Application Ref:	2025/0715			 Ribble Valley Borough Council www.ribblevalley.gov.uk				
Date Inspected:	18/07/2025	Site Notice:	N/A					
Officer:	EP							
DELEGATED ITEM FILE REPORT:					APPROVAL

Development Description:	Proposed single-storey extension to rear.
Site Address/Location:	37 Waddow Grove, Waddington BB7 3JL.

Consent is sought for a non-material amendment to application 3/2025/0506 which granted consent for the construction of a single-storey rear extension.

Proposed Elevations

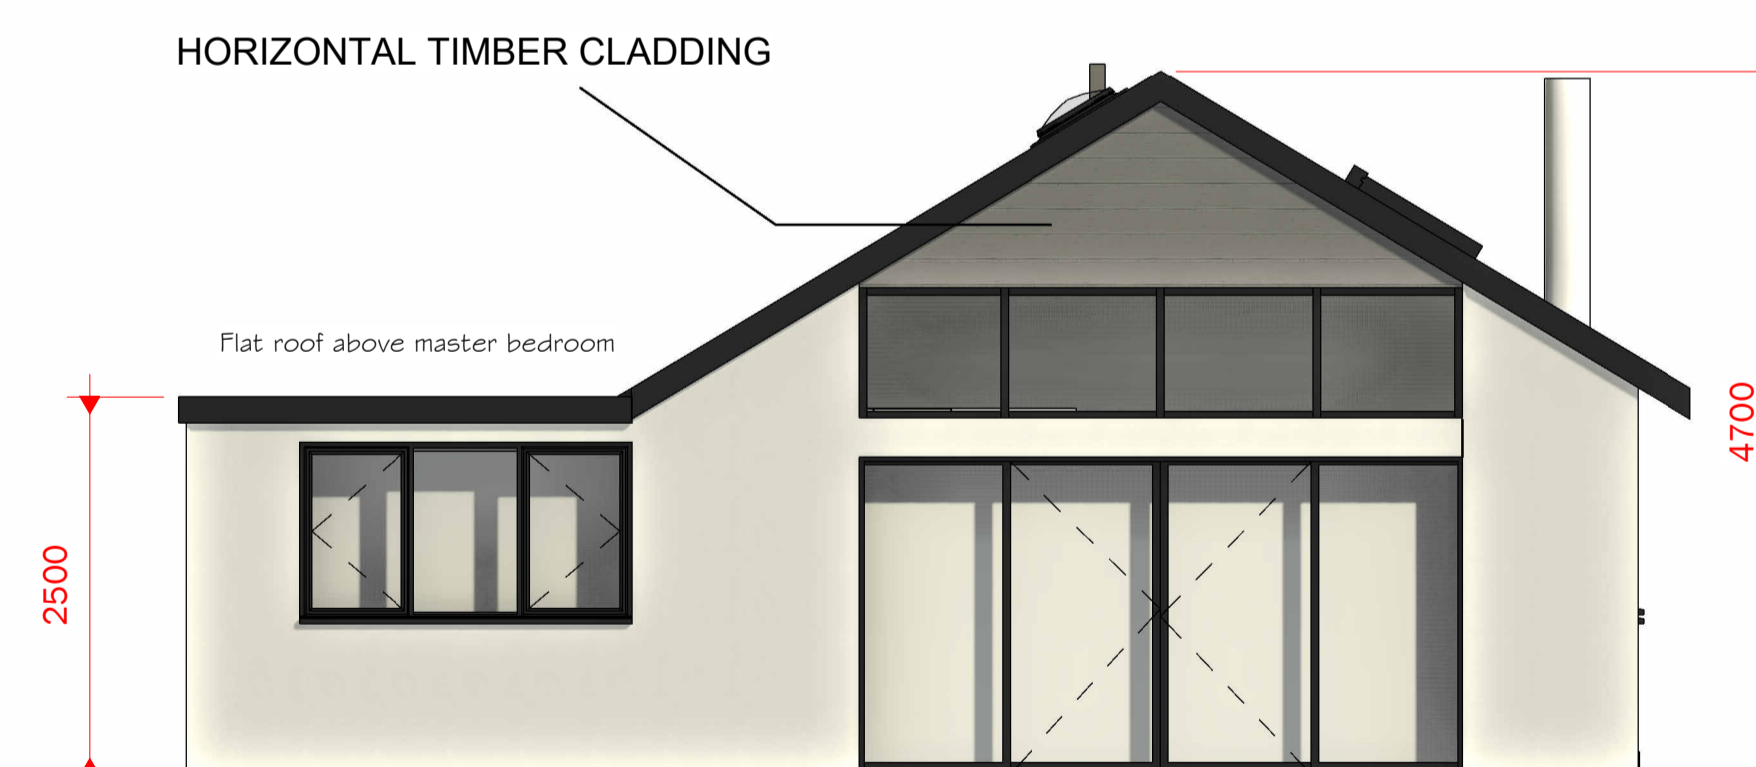
The amendments sought relate to the introduction of cladding to the rear elevation and changes to the approved window arrangement. The approved scheme features a largely glazed rear elevation, it is proposed to remove the top section of glazing and instead include timber cladding. Given the modest nature of this alteration and the screened location of the rear elevation, it is not considered this change would have any adverse impact. The approved scheme featured two narrow sections of glazing in the southeast elevation of the dwelling, these are to be replaced with one singular, slightly larger window opening. Again, given the screened location and modest nature, this raises no concerns. As such, the proposed alterations are considered acceptable.
